**From:** Jeff Watson  
**Sent:** Friday, July 12, 2013 11:47 AM  
**To:** 'Traci Shallbetter'  
**Cc:** Doc Hansen  
**Subject:** RE: Carlson Campground CUP

**From:** Traci Shallbetter [mailto:[traci@shallbetterlaw.com](mailto:traci@shallbetterlaw.com)]  
**Sent:** Friday, July 12, 2013 11:34 AM  
**To:** Jeff Watson  
**Subject:** Carlson Campground CUP

30-foot access easement between/through Bates Parcels 10 and 11

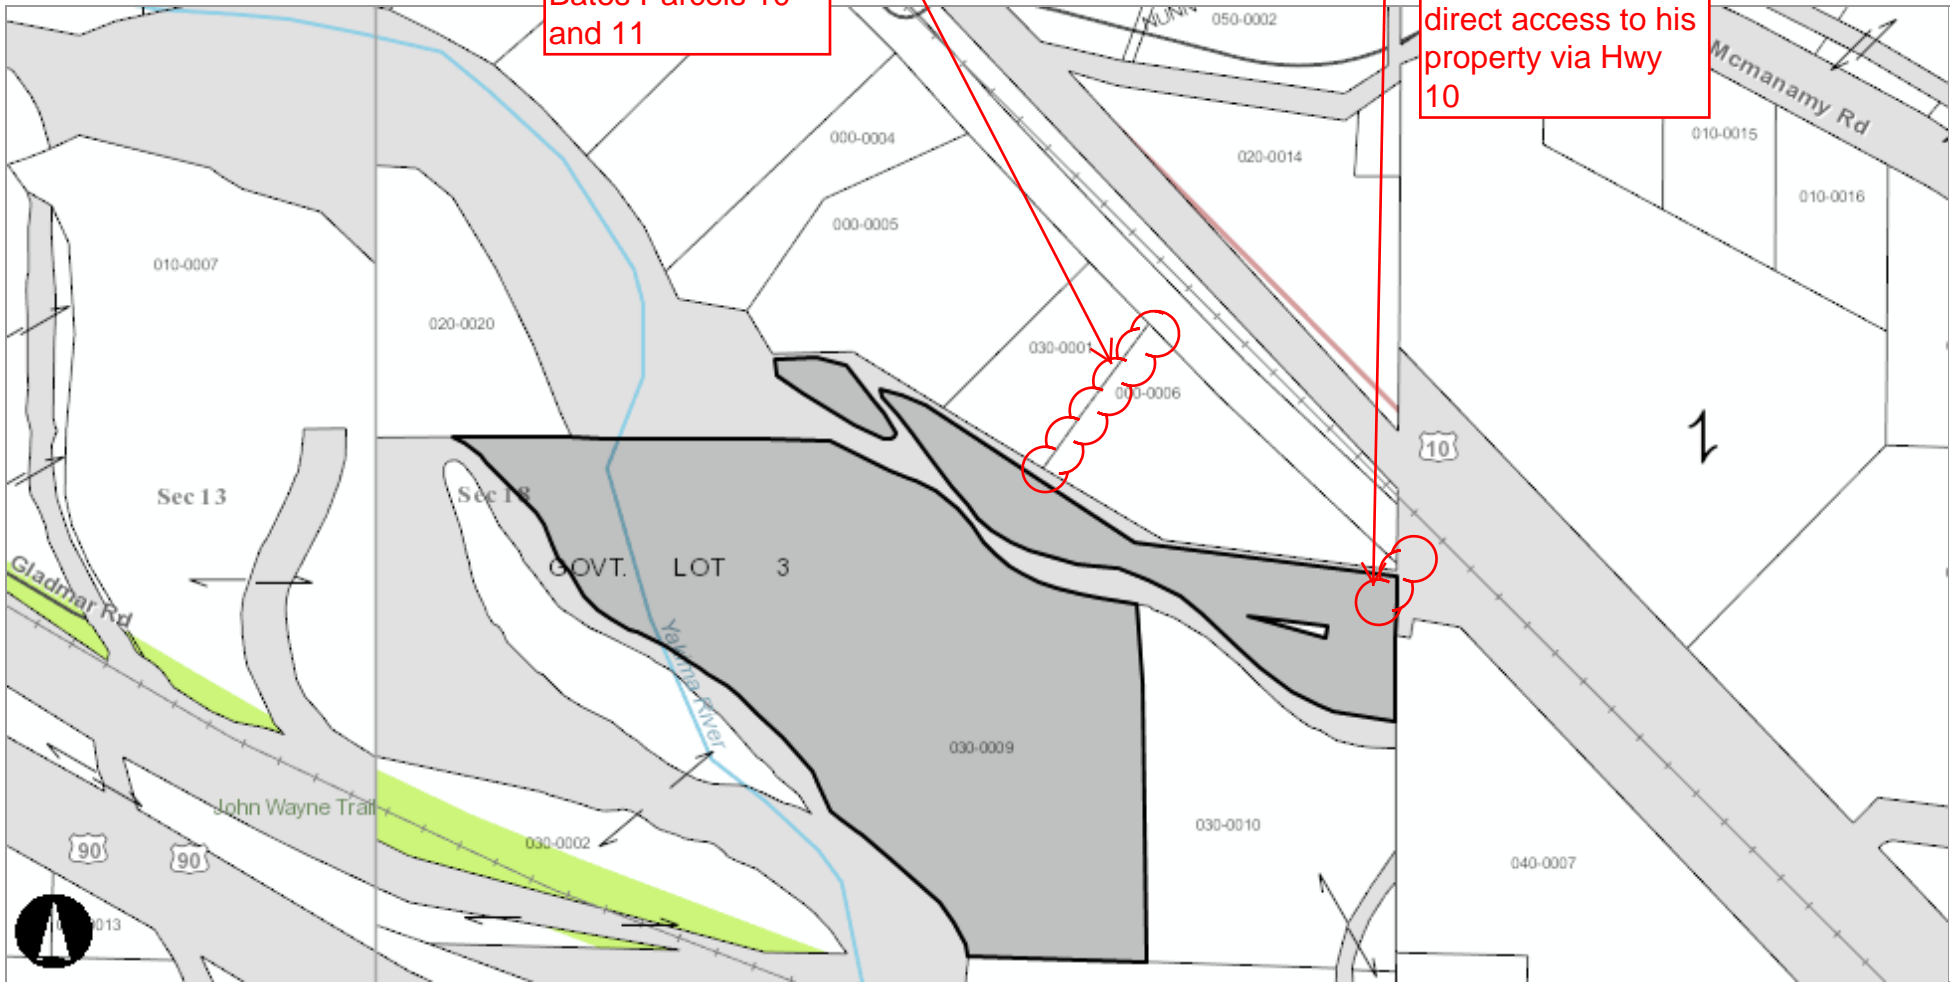
Also, we want to be sure that you are aware, at the earliest opportunity, that Carlson has only a 30 foot easement through their property (pursuant to the document recorded under Kittitas County AFN 562468) for the limited purpose of ingress, egress, and utilities. (See attached map showing location of 30 foot easement). There is a great deal of past history pertaining to Carlson's use of the easement/allowance of use of that easement by commercial guide services without a CUP, and, as will become evident in the comment process on Carlson's application, my clients have grievous concerns about the impacts and undue burden that would result to their property and adjacent properties if Carlson were permitted by the County to utilize the subject 30 foot easement for commercial purposes that would involve travel by large campers, RVs, etc. on a frequent basis.

Not only would such proposed use overburden the easement in terms of Carlson's private rights of access, but it would present public safety dangers in light of the camper and boat traffic that would be crossing the railroad tracks and passing over an unimproved 30 foot wide road through the two lots owned by the Bates. Already

there have been multiple incidents with Carlson-authorized boats/guide services coming dangerously close to hitting one of the Bates' dogs or the Bates' guests. The public safety concerns and disruption, [are](#) in addition, to the noise, dust, light/glare from the campers, cars, and traffic that would result if the County were to authorize Carlson's use of this 30 foot easement for the proposed commercial purposes involving a campground and launching area. It does not seem that it would be appropriate or legal for Carlson to utilize the 30-foot easement for his commercial purposes—particularly when considering the elements of Footnote 12 to KCC 17.15.070. We would hope that Carlson or the County would propose that Carlson utilize or create a direct access to his property from Highway 10—one that does not rely on crossing through the private property of others. (See note on attached map suggesting access route that Carlson should use/create if he intends to have a commercial campground and fishing enterprise on his property).
